From: Gary Bottwood [REDACTED]
Sent: 06 May 2021 19:34
To: Finlay Gardner <Finlay.Gardner@arun.gov.uk>
Subject: Re: Planning resubmission BE/59/21/HH

We are aware that a planning application has been resubmitted and the residents of Bedford Avenue are asking me where they can object. The plans only differ by having lines added to indicate visibility splays. However the splays do not account for trees adjacent to the property reducing visibility to far less than the 43 Mtrs required.

SITE PLAN - SHOWING VISIBILITY SPLAYS
1:500 SCALE (at A3)

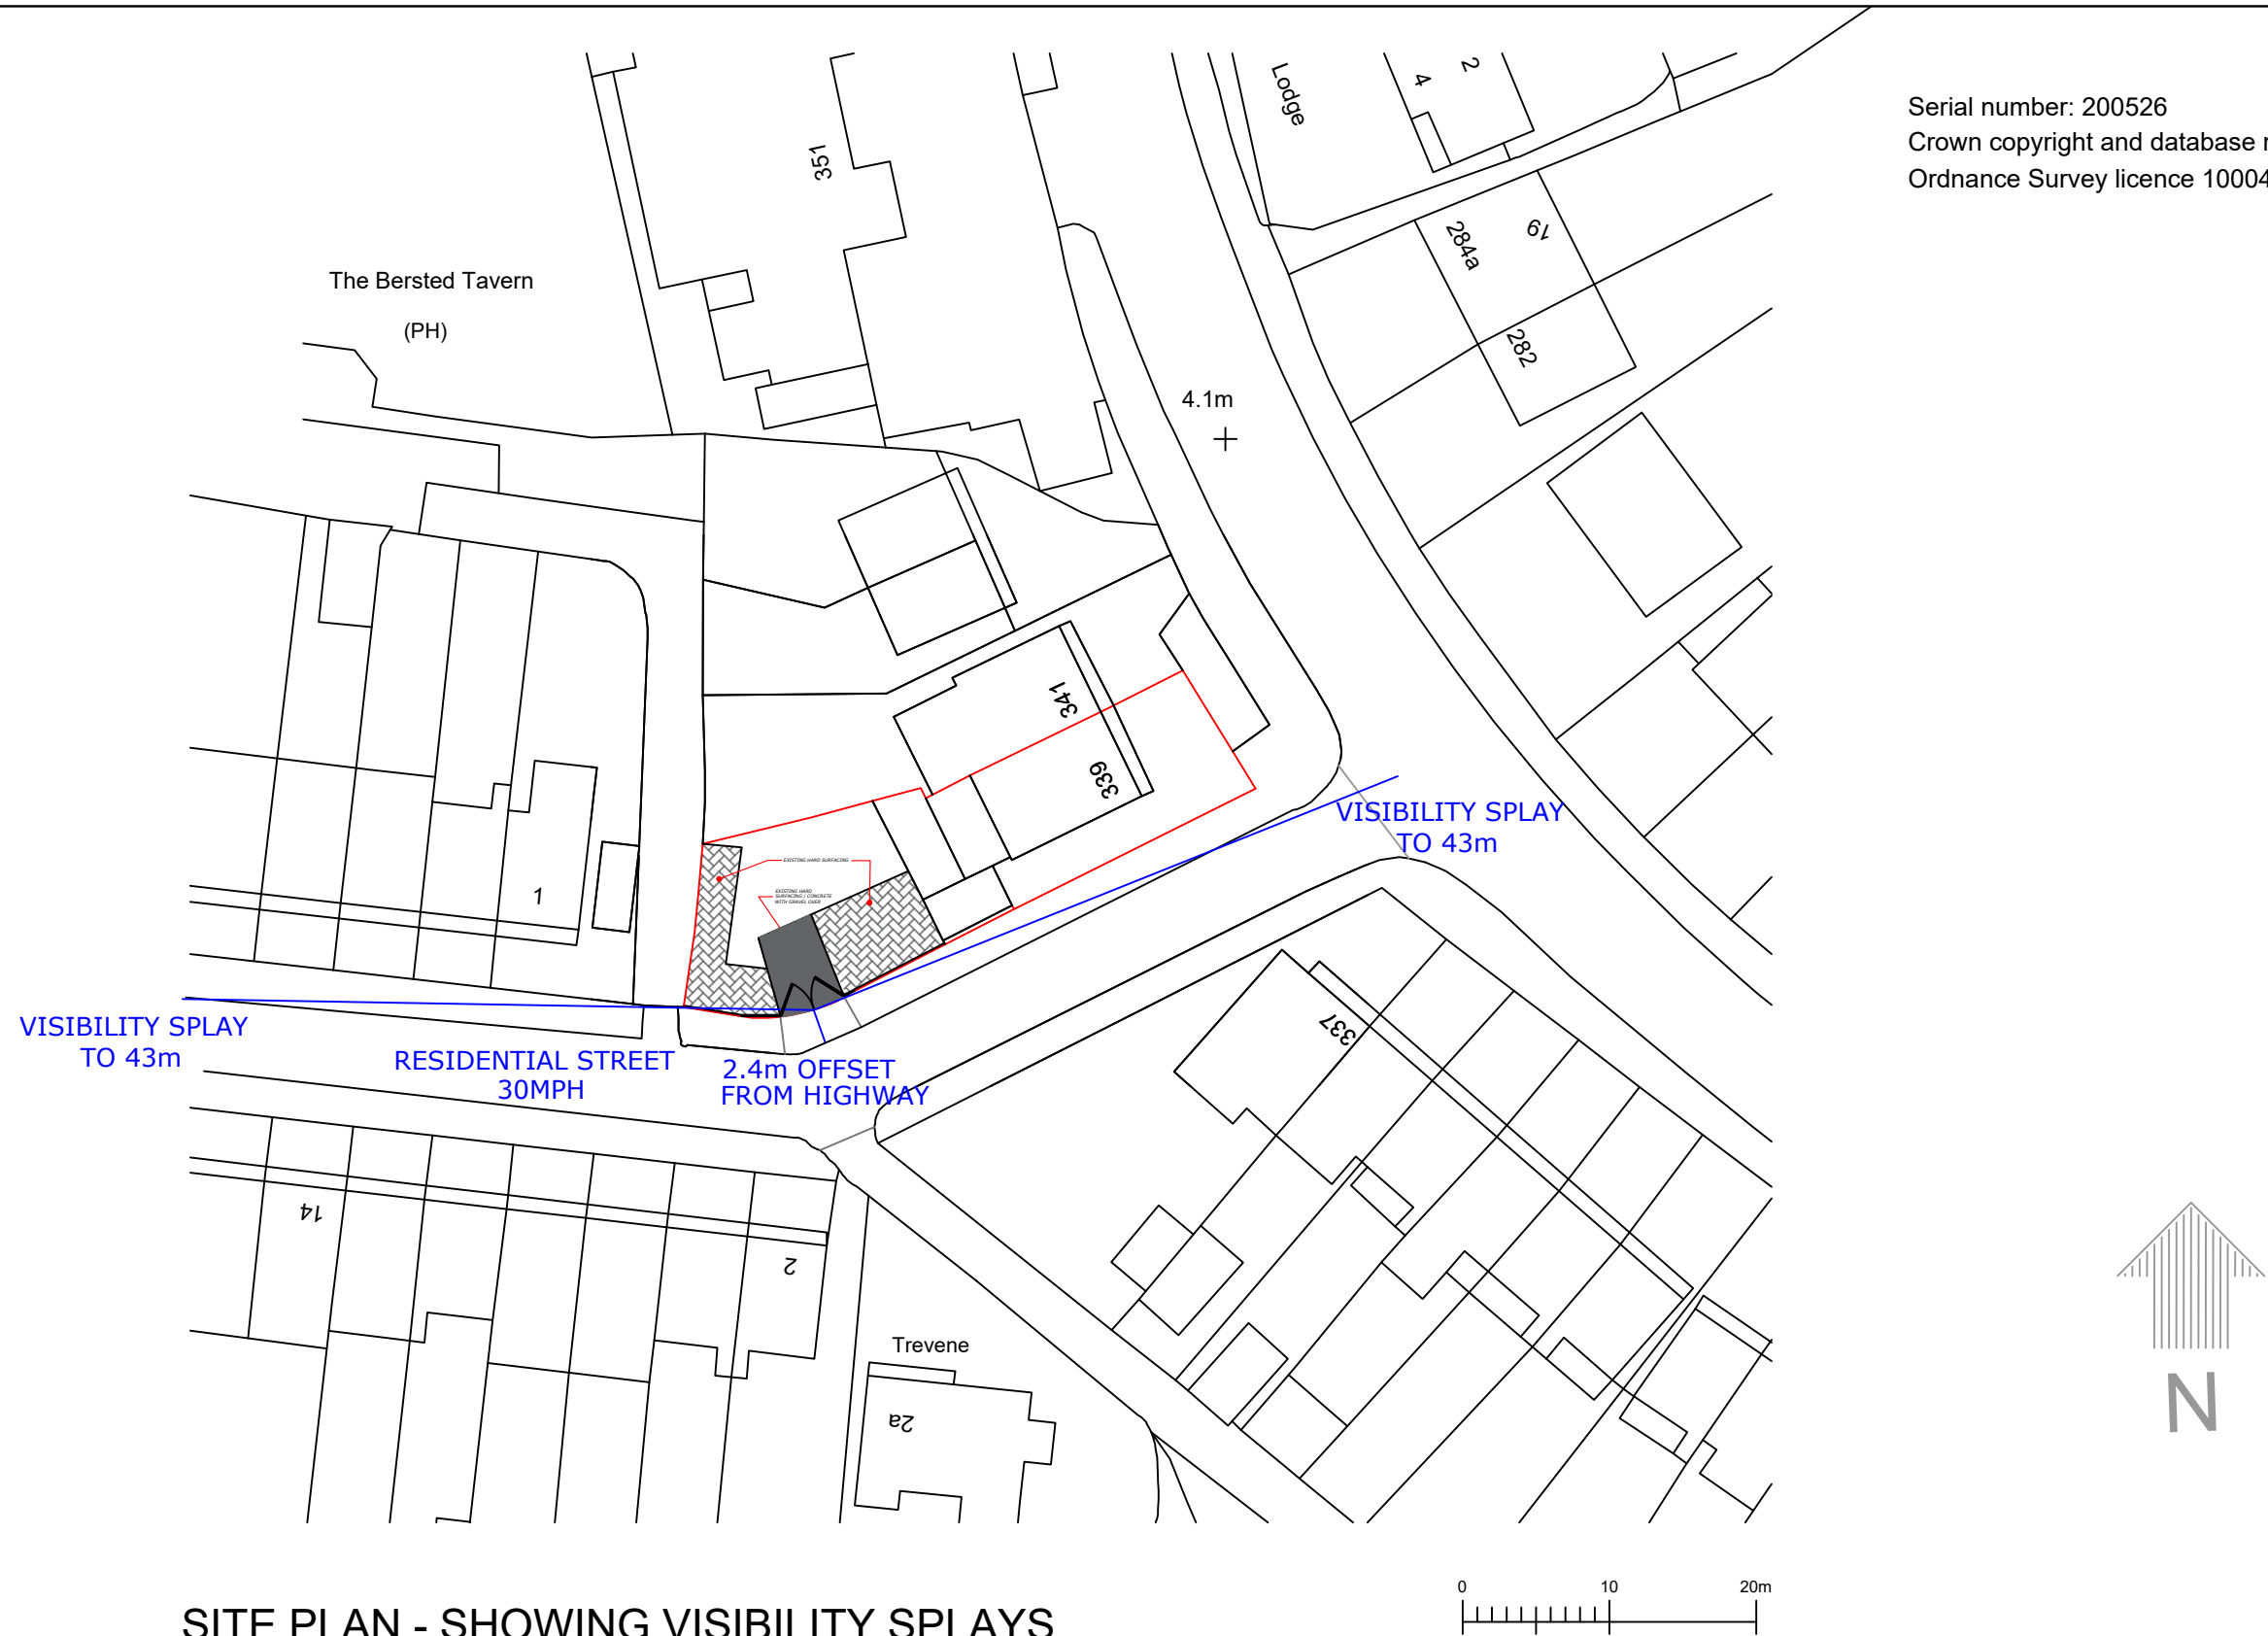
We have attached copies of the plans with the Drop Kerb positioned correctly and tried to show how the plans submitted, having the dropped kerb incorrectly positioned, favours Mr Delaneys Application and his attempts to meet the visibility requirements. You will also notice the gates in the plans are not positioned 5 mtrs from the curb as required by Highways. Overall the visibility requirements are unobtainable as pointed out by Highways correspondence during the previous application due to the residents parking on the curb either side of the drop kerb, legally, reducing visibility to well below the minimum of 43 mtrs required.

Even if the Drop Kerb was positioned where it is shown on the plans the parked cars would wipe out any visibility. At present the plans show the visibility of the driver being a view of the inside of the boundary fence if a 6 ft fence is used.

A picture attached shows the actual positioning of the Drop Kerb against the Site Plans positioning in Mr Delaneys latest Application. For the plans submitted the current Drop Kerb would need relocating which still wouldn't address the point where the calculation for the visibility splays is measured being wrong on the site plans.

The photo clearly shows the drop Kerb doesn't straddle the apex as shown in the plans. This means visibility is actually far more restricted.

The other issue with the revised Application is the positioning of the Drop Kerb In the drawing. The drawing suggests it is on the apex of the bend where as it is actually flush with the wall in the direction of Chichester Road. Unless Mr Delaney intends to extend the Drop Kerb 1m towards Chalcroft Lane it isn't an accurate representation

The fence is not compliant with the 600 mm maximum height required by highways as ordered by Ben Whiffin as a condition of the licence being issued in September 2019. As there has been no subsequent inspection the renewal of the Drop Kerb licence would be issued under the same conditions required by Ben Whiffin.
